Arun District Council
Arun Civic Centre
Maltravers Road
Littlehampton
West Sussex BN17 5LF
Planning & Building Control General Enquiries
Tel: (01903) 737756 Fax: (01903) 730442
Dx: 57406 Littlehampton
Minicom: 01903 732765
e-mail: planning@arun.gov.uk
website: www.arun.gov.uk/planning

Application No: CM/45/20/HH
Site Address: 2 Atherington Cottages Climping Street Climping BN17 5RN
Description of works: Construction of 3 x dormers to the east elevation of the house and construction of a detached garage and workshop

Thank you for your internet representation made on 25th November 2020 which has been recorded as no objection with the comments as follows:

DRAWING TITLE
PROPOSED ELEVATIONS AND SECTION

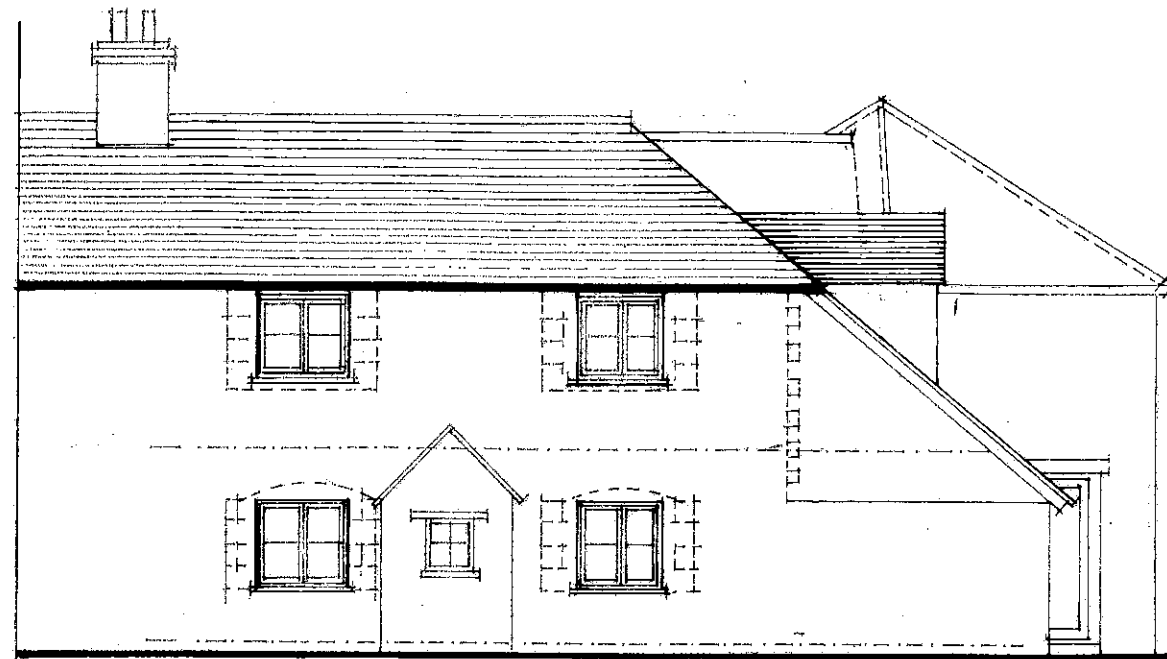
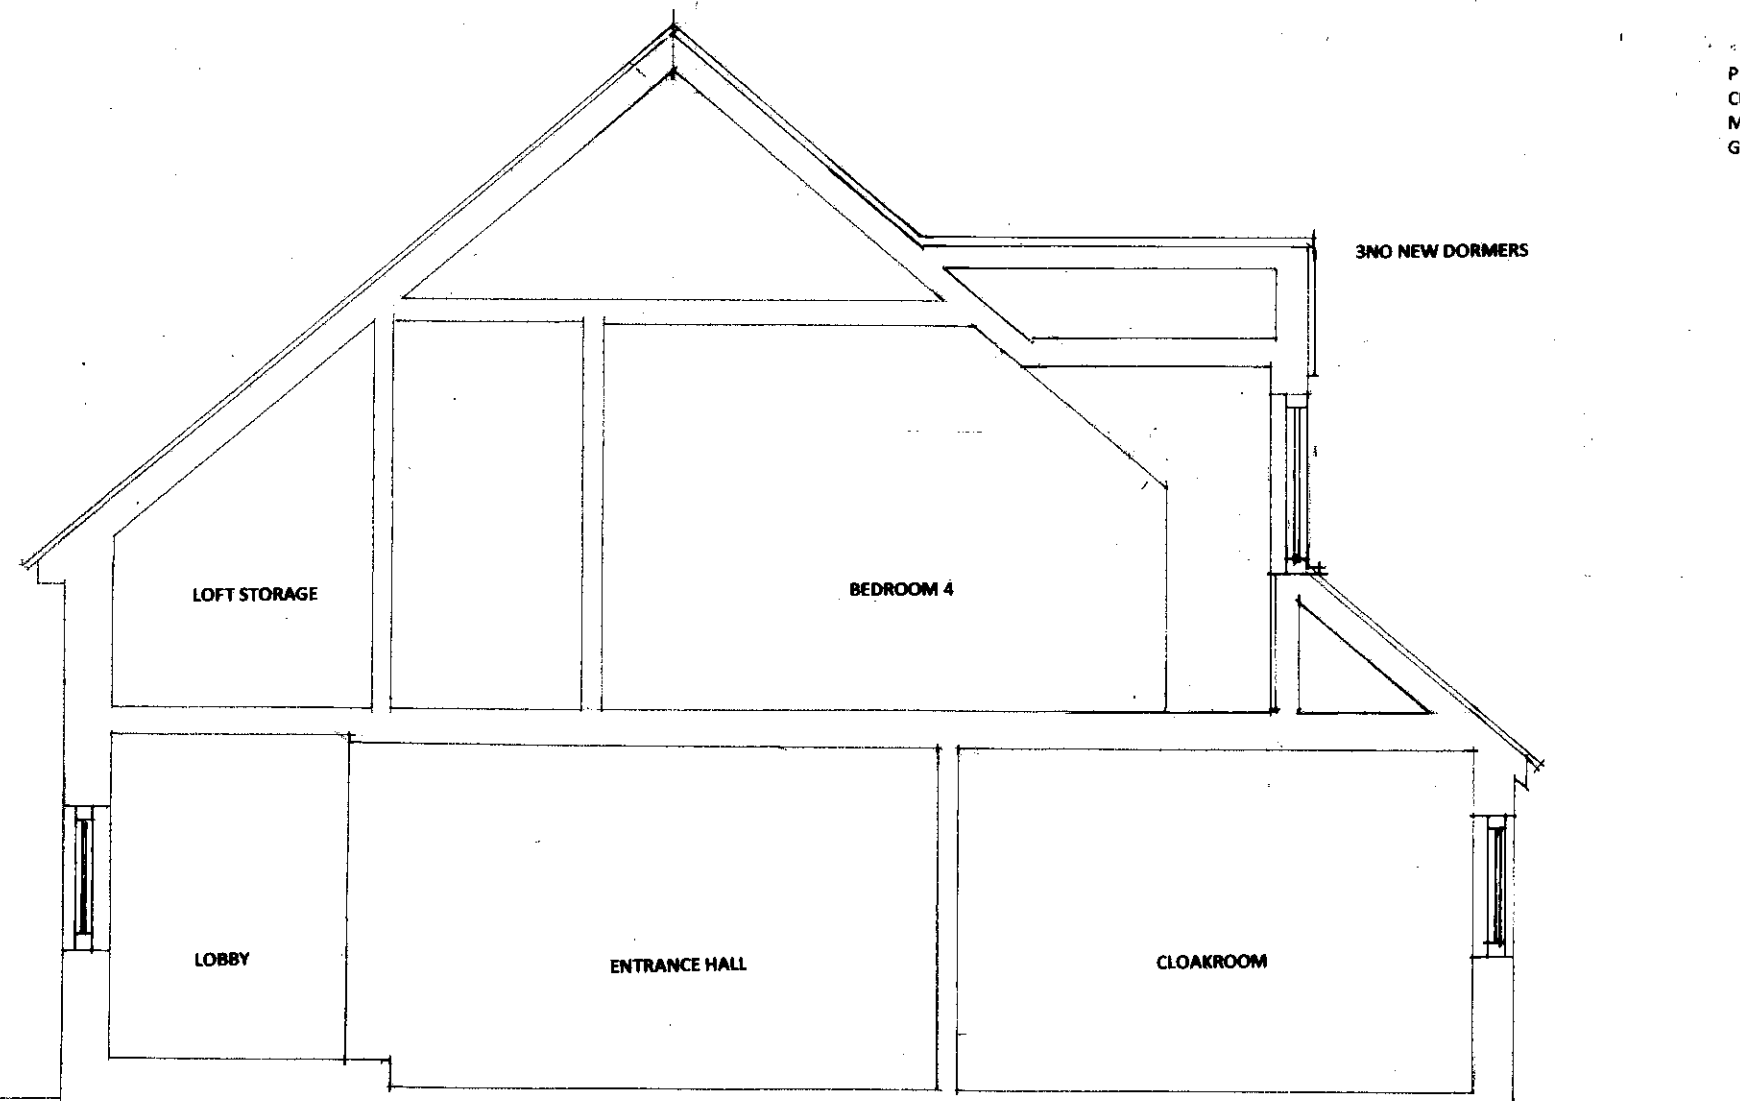
No Objection as long as the materials used are in keeping with the existing property and the neighbouring property.
